From: Michael Eastham <Michael.Eastham@arun.gov.uk>
Sent: 28 April 2021 08:02
To: Planning.Responses <Planning.Responses@arun.gov.uk>
Subject: FW: *EXTERNAL: RE: Felpham - FP/248/20/PL

Please upload onto Ocella the email below which is the further consultation response from the **Local Highway Authority** to planning application **FP/248/20/PL**.

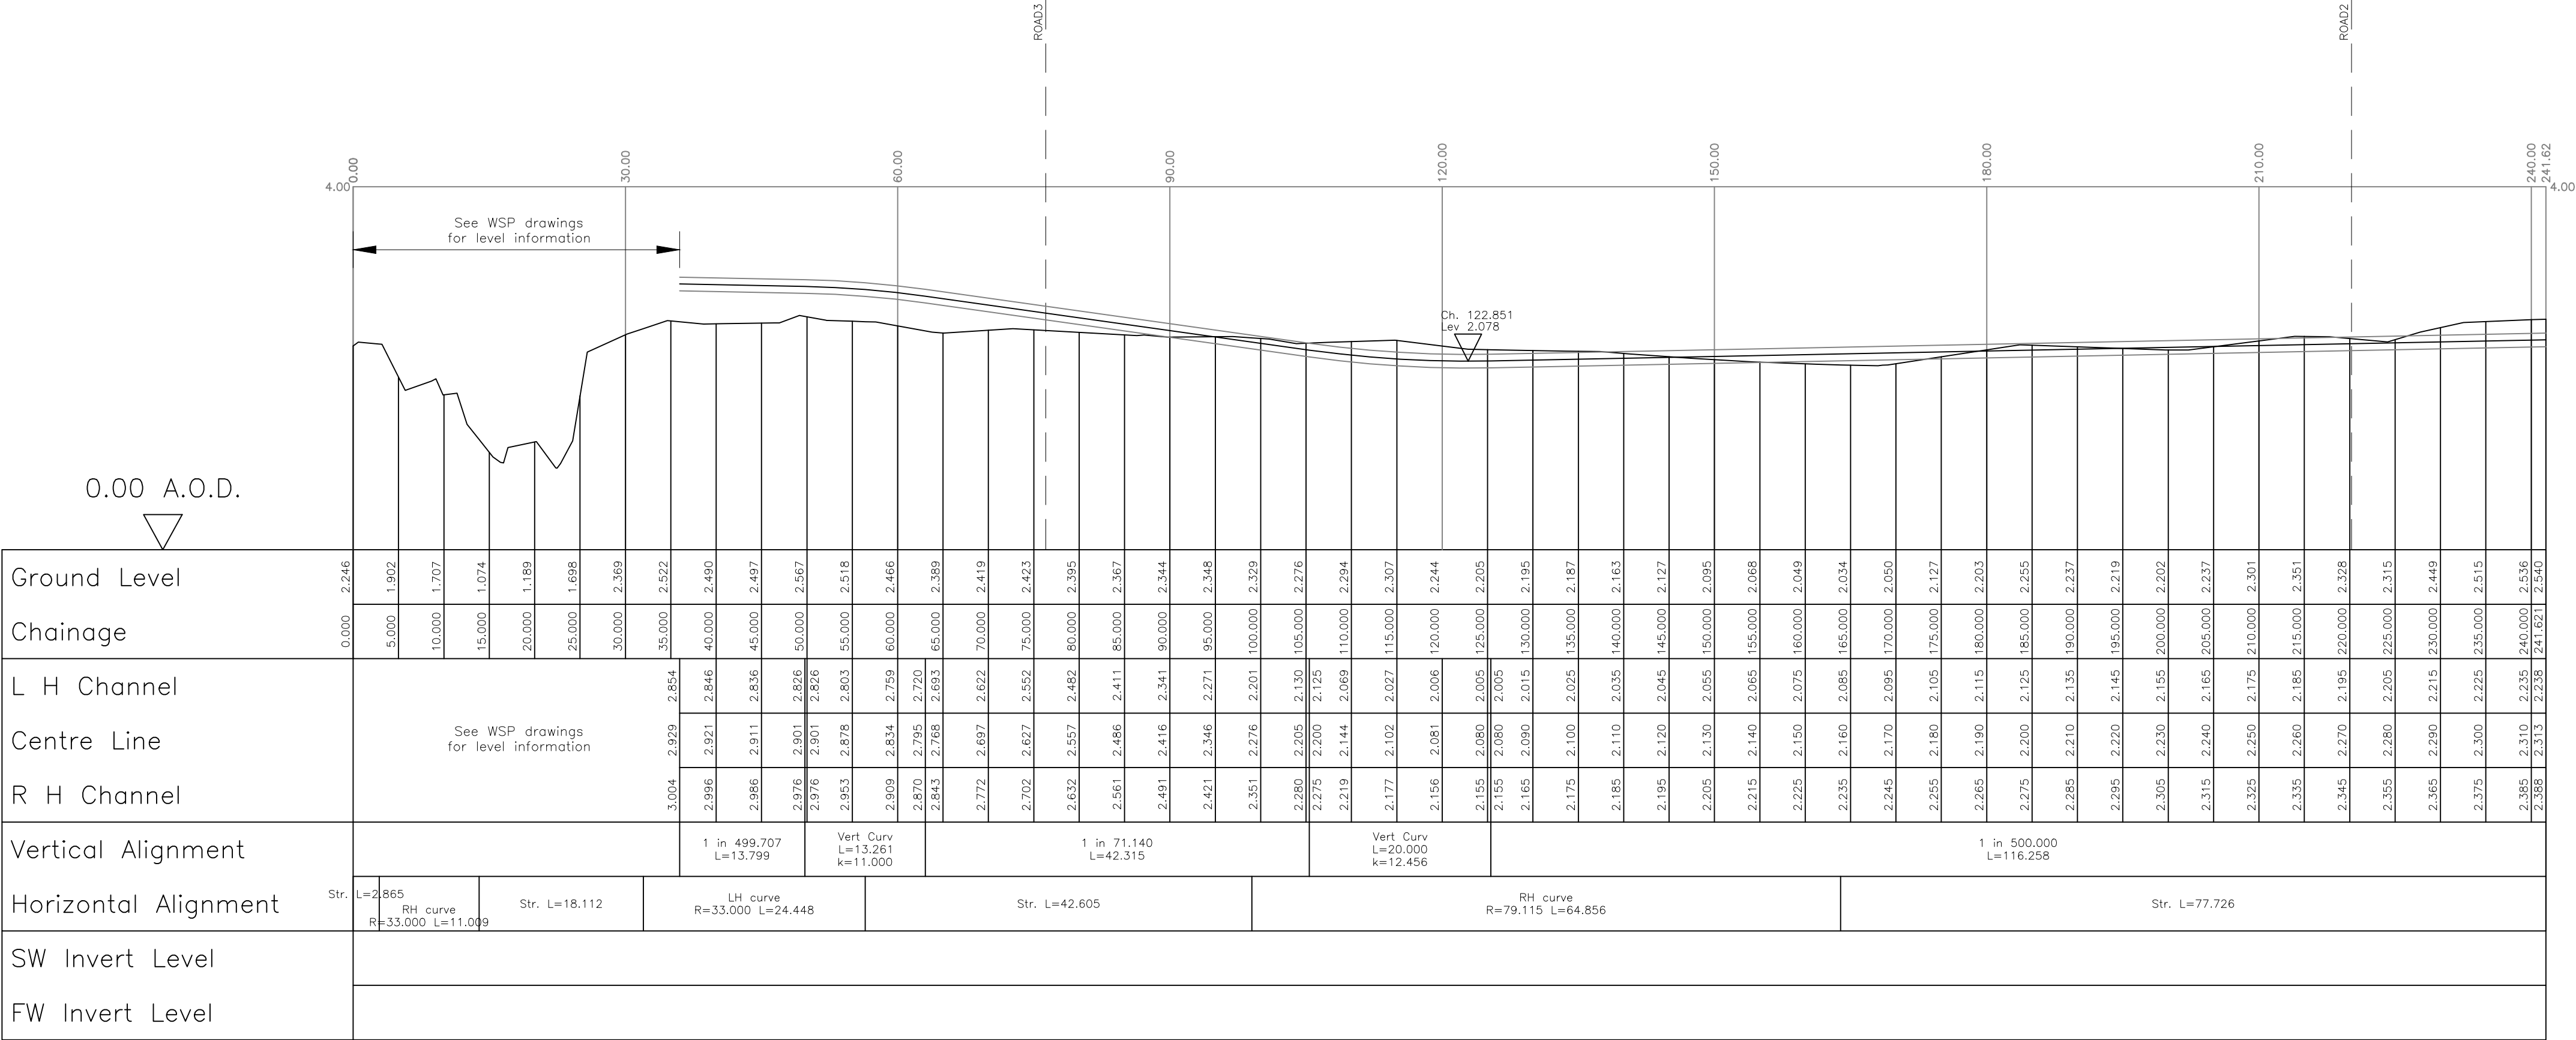
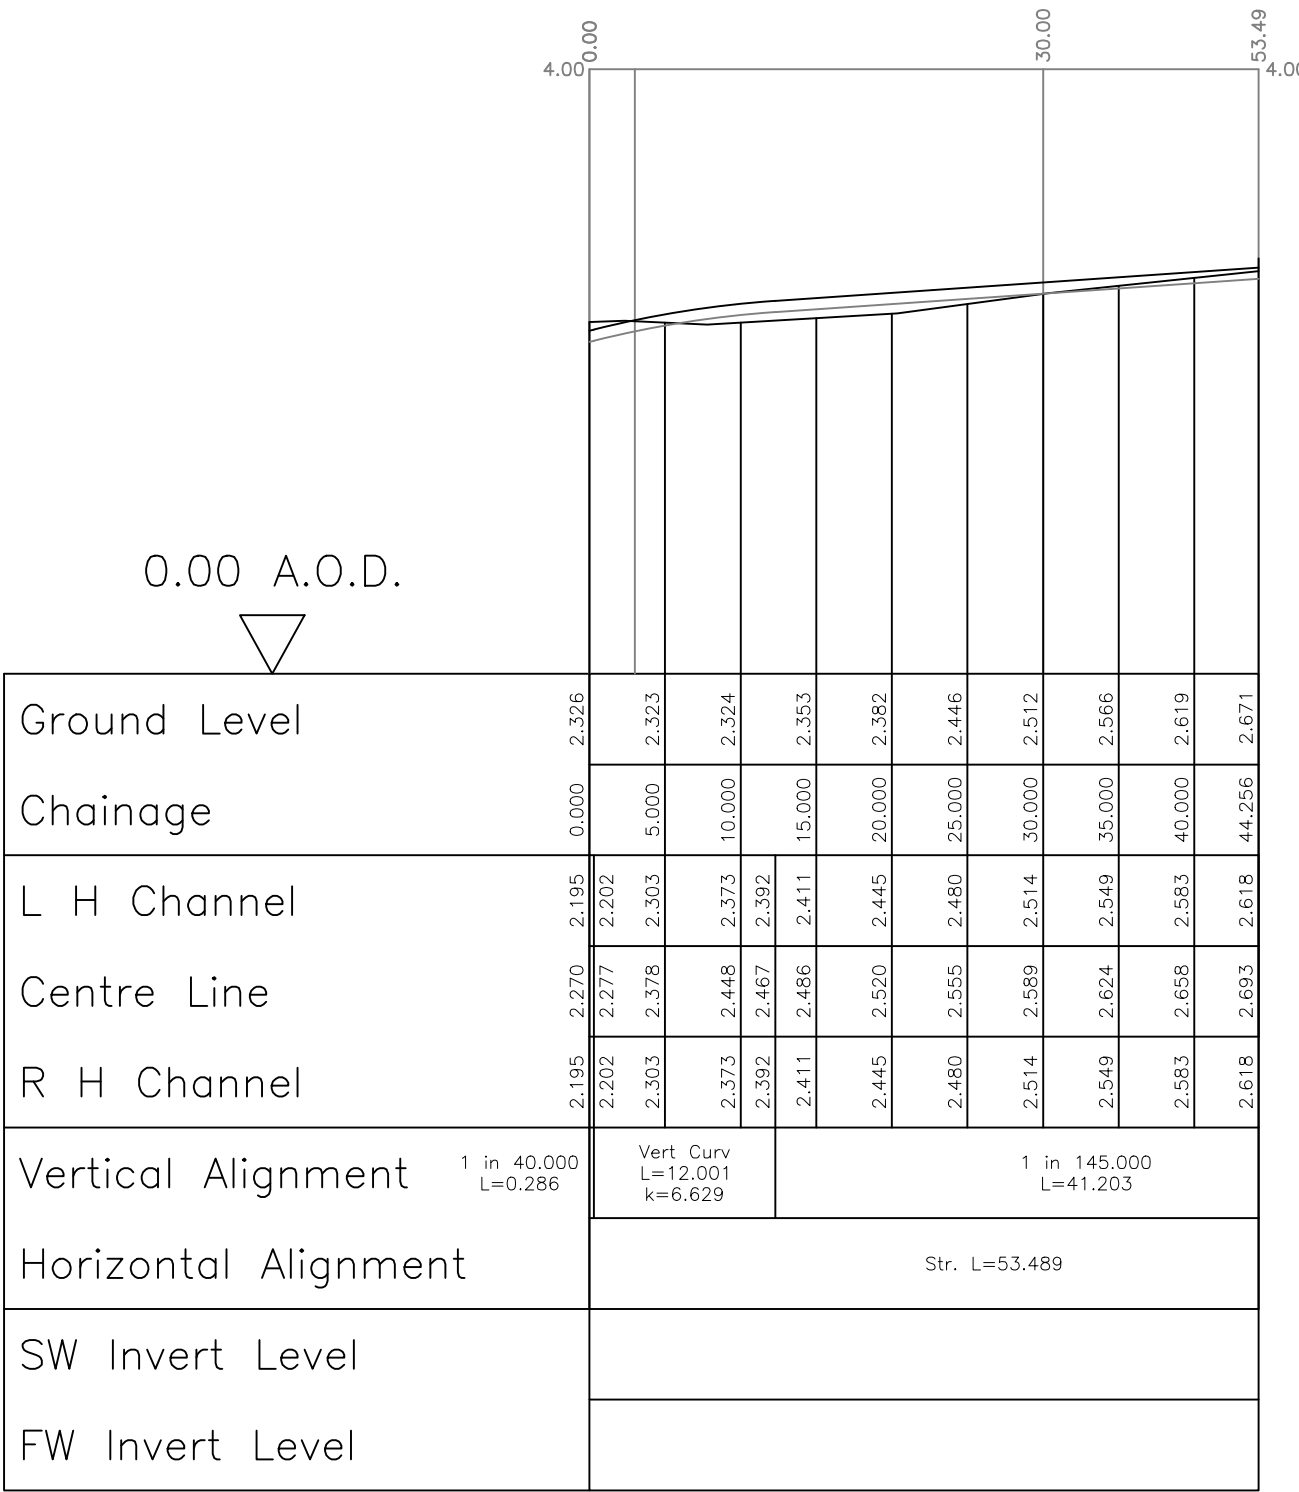
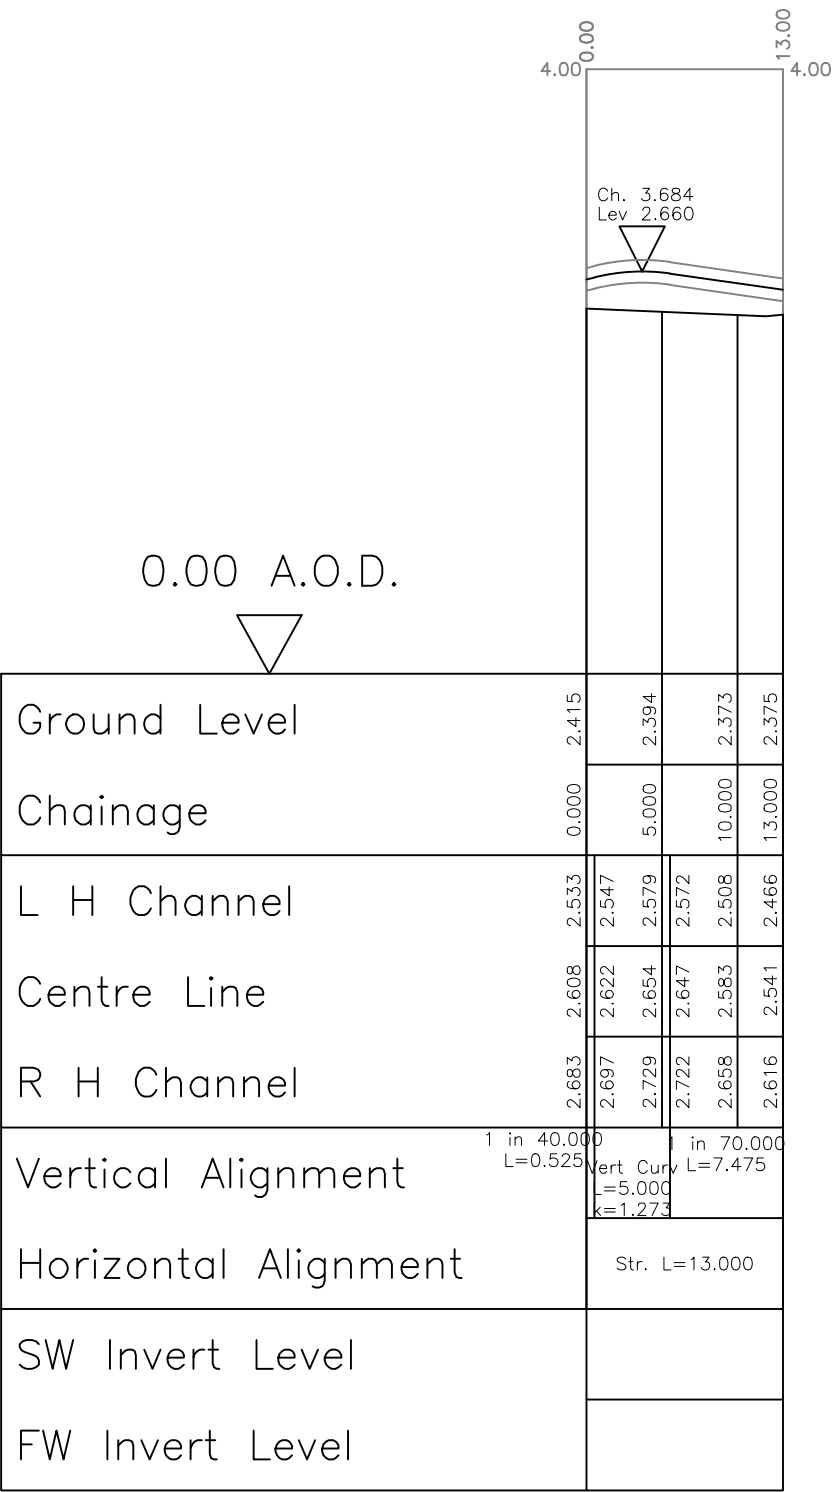
The sections provided are more for Detailed Design. I would need to see a 1:1250 detailed site plan showing the dimensions of the access/footway. From what I recall these were not included on the latest submission.

In your consultation response you requested "Further information is required on the access road/footway and its dimensions".

“The application relates to the sport pitch and changing facilities building, originally approved by Reserved Matters consent Y/68/09. Relative to the exiting permission the current application proposed revised pitch dimensions and location and revised dimensions and specification for the changing facilities building.”

Is this information required for an approval? The road and footway were approved by the previous consent and BDW are not proposing any alteration to this area. Relative to the existing permission BDW are seeking only to make alterations to the changing facilities building, and move the football pitch slightly further south.
